Application no: **3/2022/0136**

Address: **Former garages Back Brennand Street Clitheroe BB7 2HB**

Proposal: **Internal remodelling, replacement roof, limited demolition and extension to create two one bedroom apartments on the ground and first floor.**

The Agent has now submitted a revised plan which is provided by Stanton Andrews drawing number PL1 Rev B titled "Proposed Site Plan" and will be reviewed below.

drawing number
PL 1
revision
B

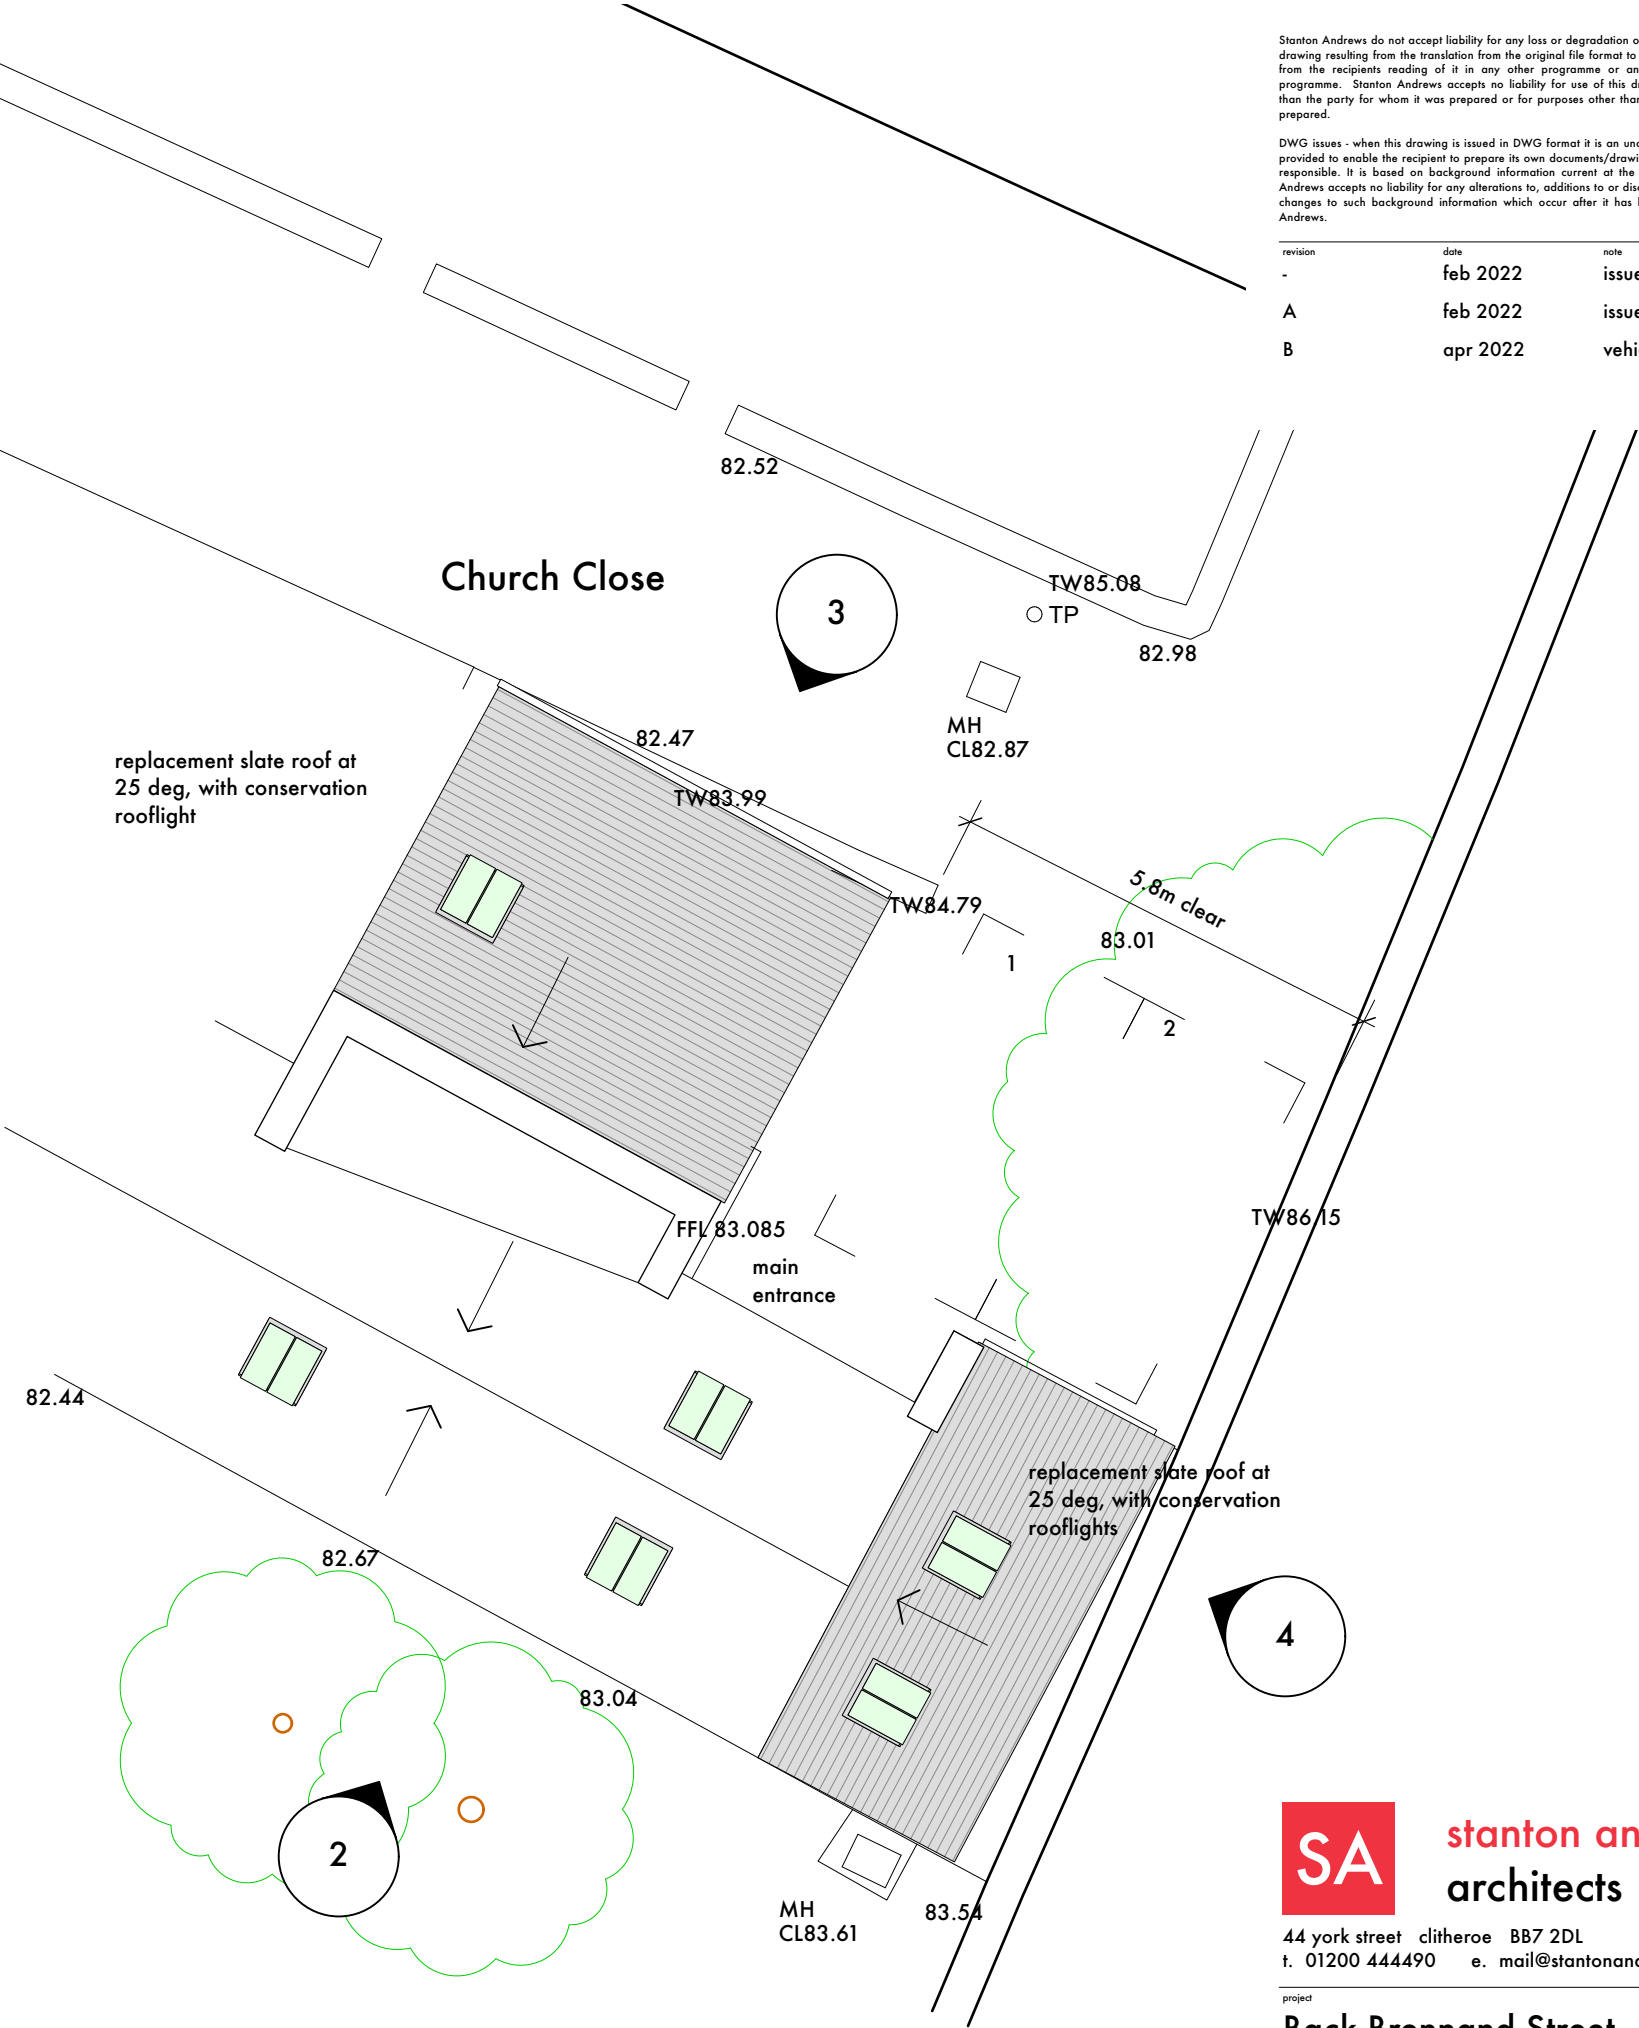
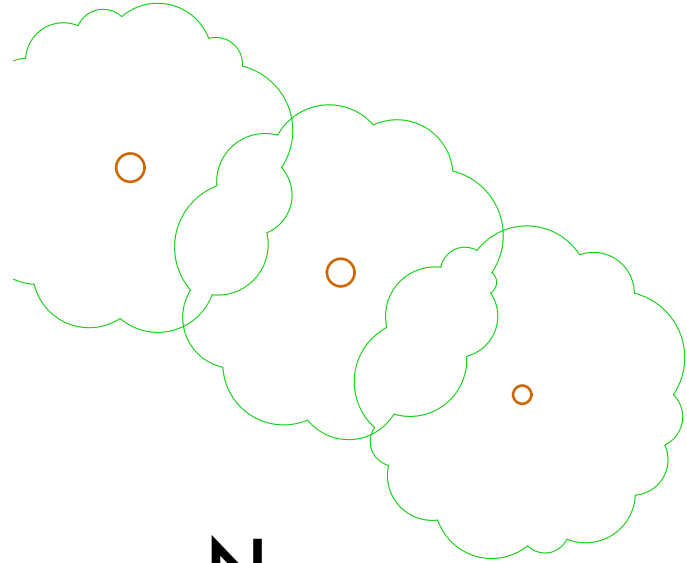
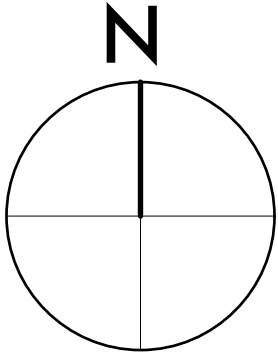
The LHA have reviewed Stanton Andrews drawing number PL1 Rev B titled "Proposed Site Plan" and are aware that the site will provide 2 car parking spaces for the 2x one bed apartments which complies with the LHAs parking guidance as defined in the Joint Lancashire Structure Plan.

The LHA have reviewed the dimensions of the spaces which now measure 5.8m wide and 4.8m in length for the 2 car parking spaces provided. The LHA welcome the increase in width of the car parking spaces, with them being bound on both sides by an existing wall and so now there is adequate space for them to be usable. Therefore, as a result, the LHA have no objection to the proposal.

2. The development hereby permitted shall not be occupied until such time as the parking and turning facilities have been implemented in accordance with Stanton Andrews drawing number PL1 Rev B. Thereafter the onsite parking provision shall be so maintained in perpetuity.
